Re: Cobbora Coal Project - Independent Groundwater Modelling Review

**PEER REVIEW OF THE COBBORA COAL
PROJECT GROUNDWATER ASSESSMENT**

Report Number: HC2012/5
Date: February 2012

Figure 4.5A Selected hydrographs showing observed versus calibrated transient groundwater heads

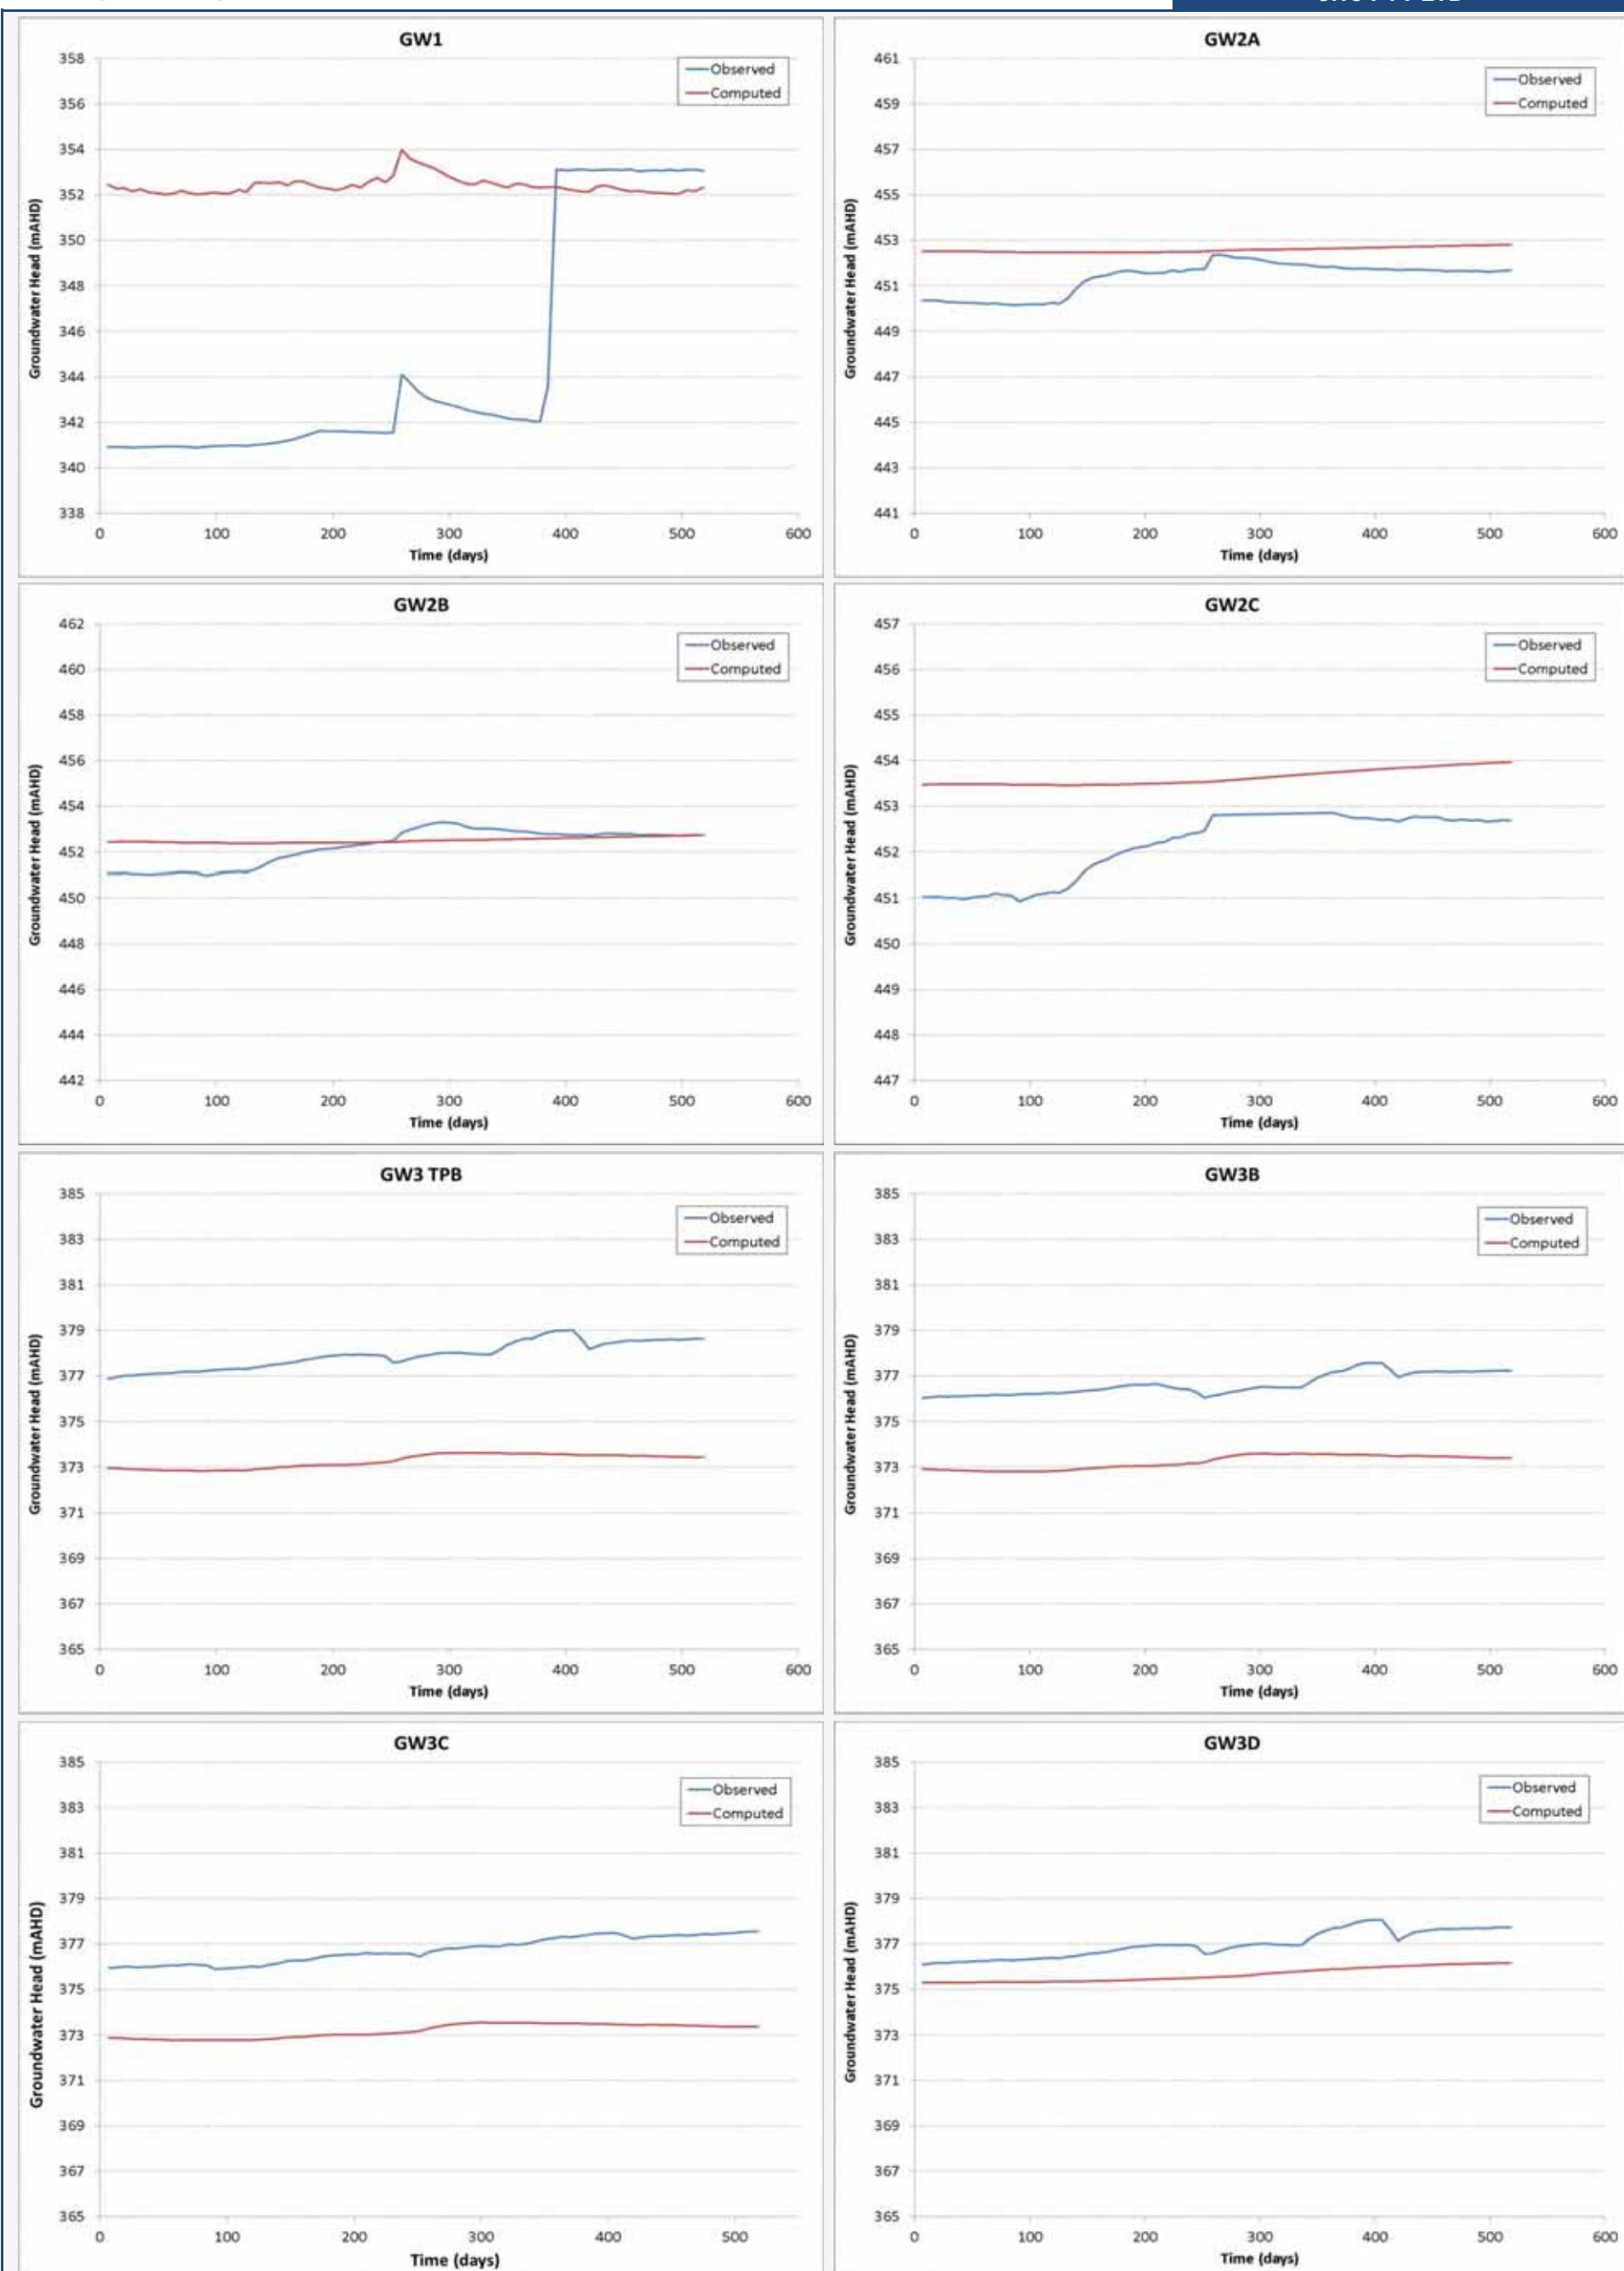
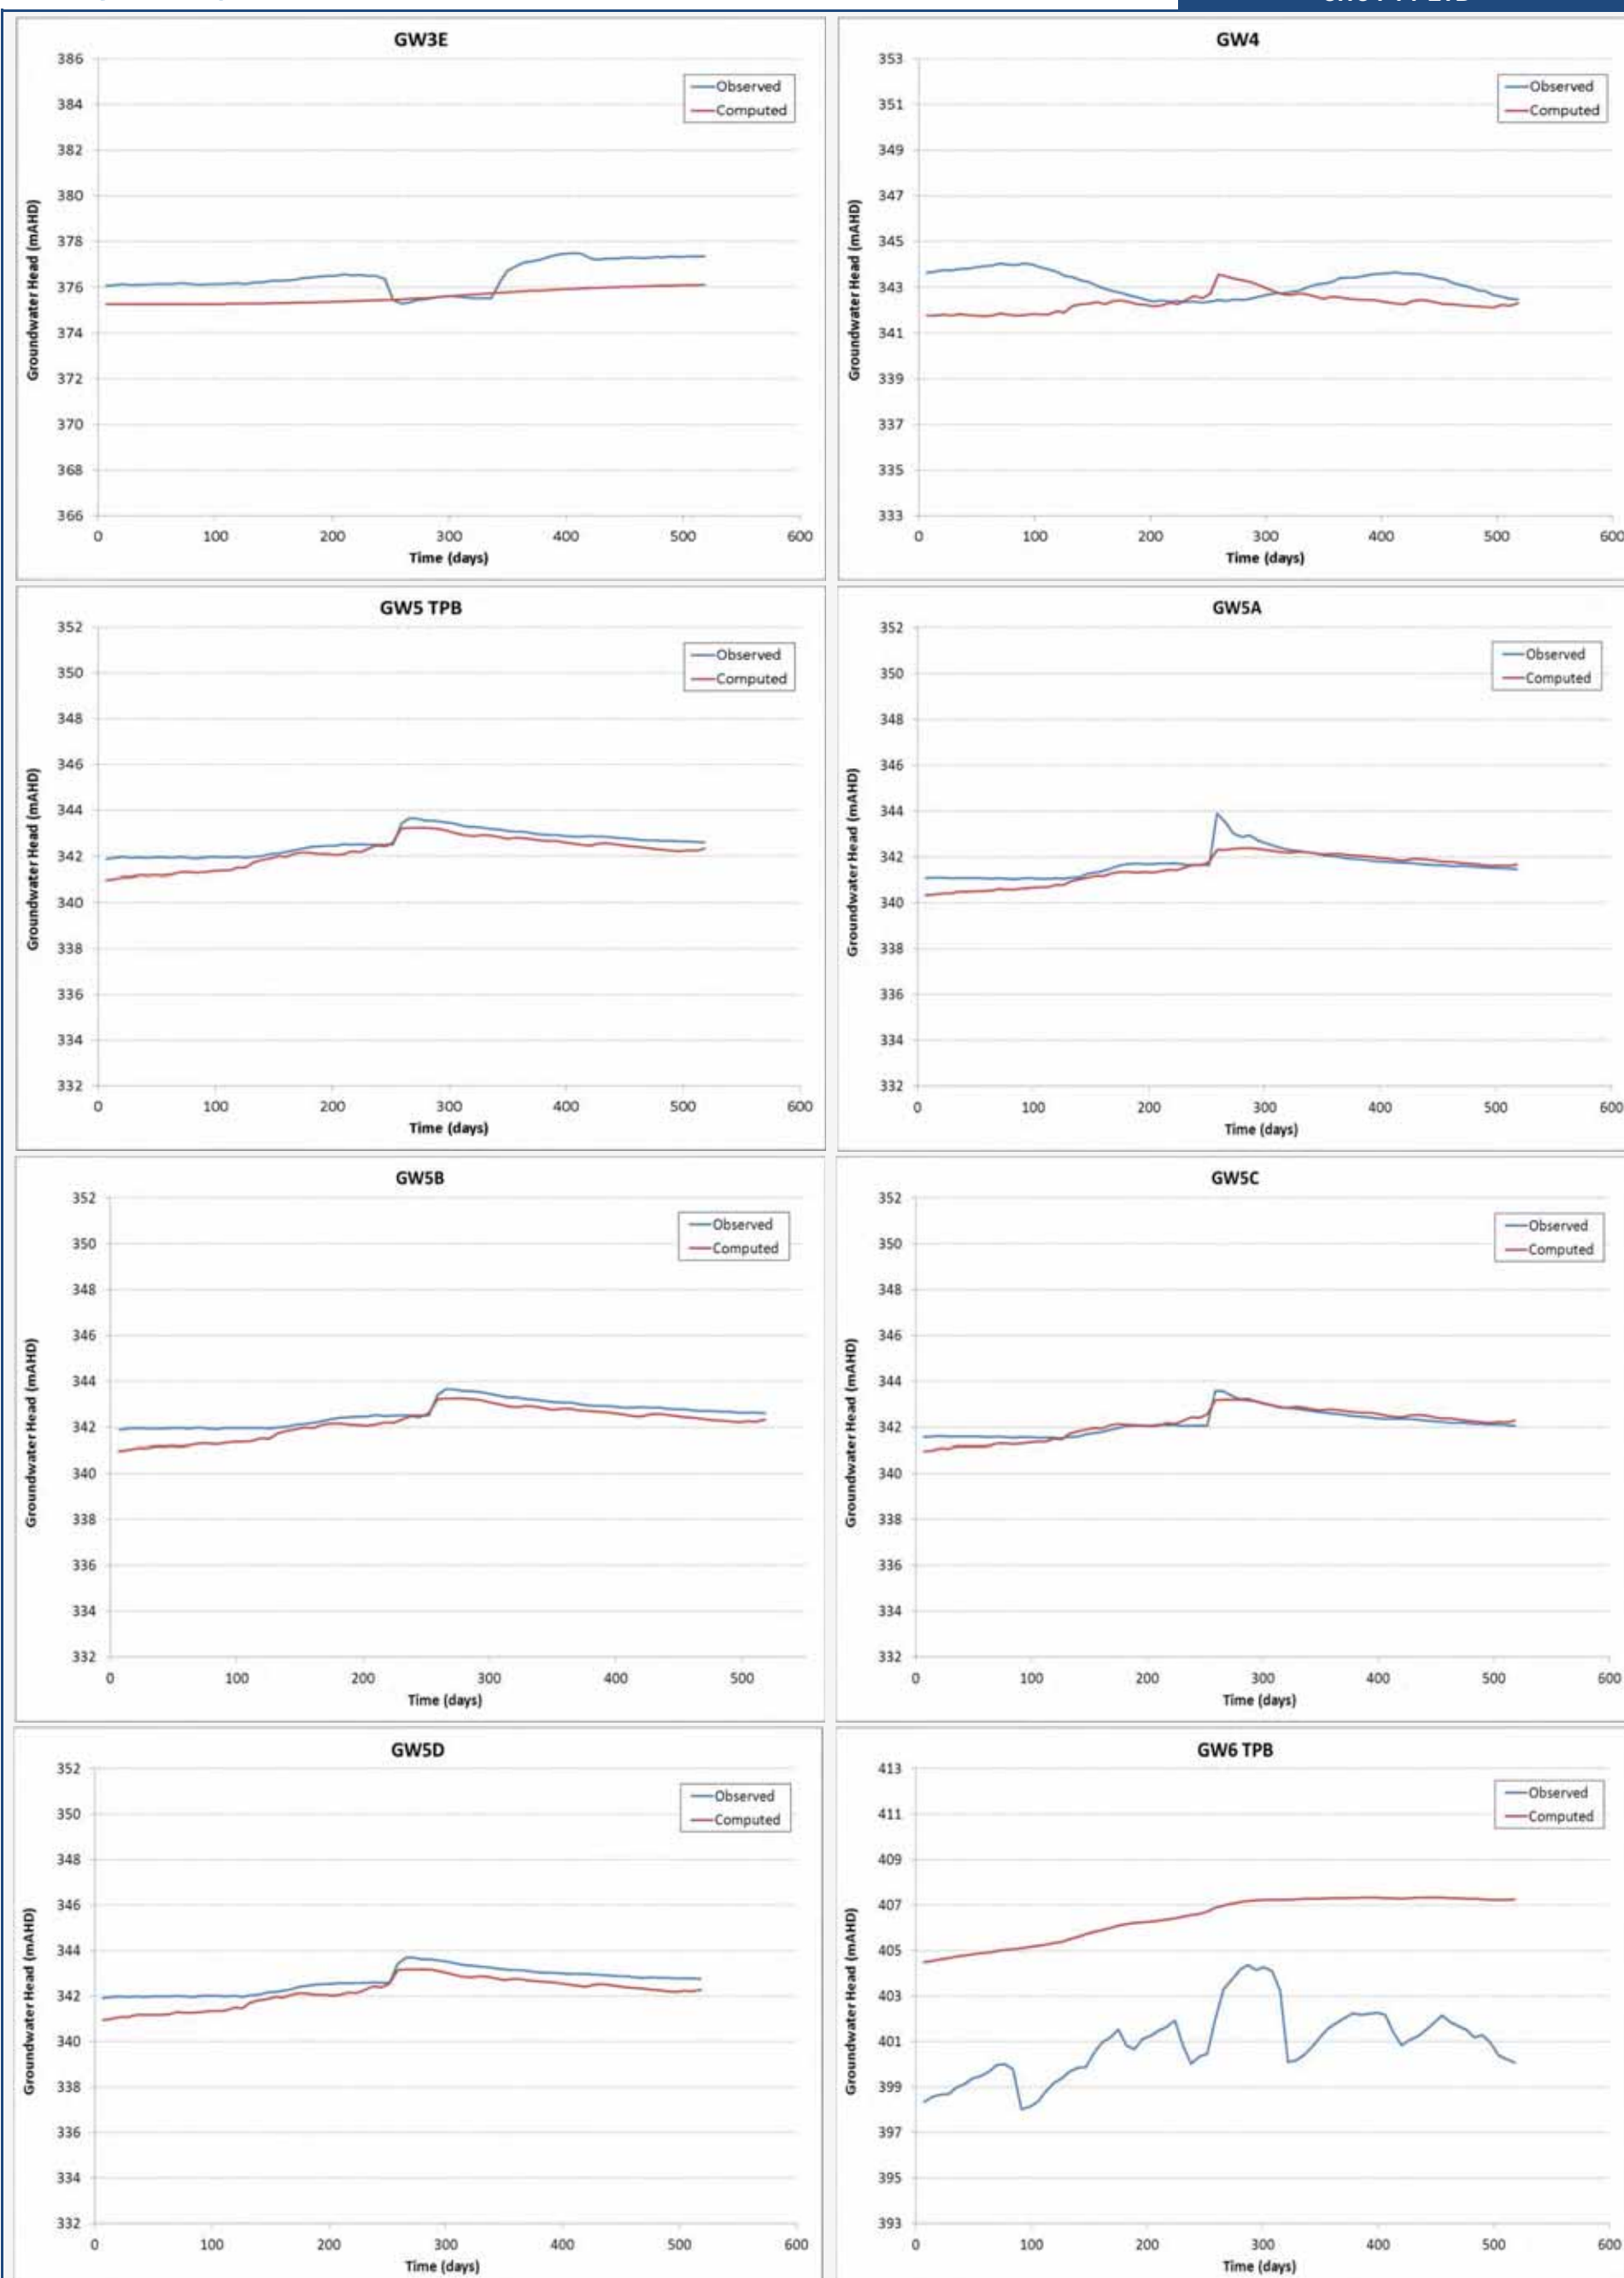
Transient calibration evidence is provided also by a scatter plot and RMS performance statistics, with examples of a few hydrographic matches. The transient performance is measured at 2.4 %RMS and 4.1mRMS, which is quite good. However, not all hydrographic matches are presented. Of the eight comparisons that are presented, only two are particularly good (in alluvium at Bore GW5A) and in the Digby Formation (at Bore GW5B). The others generally suffer from offsets in absolute value, although trends are

generally good. Without seeing the full set of hydrographic matches, or a residuals map, it is not possible to say which areas of the model are well calibrated or which natural processes are well replicated.
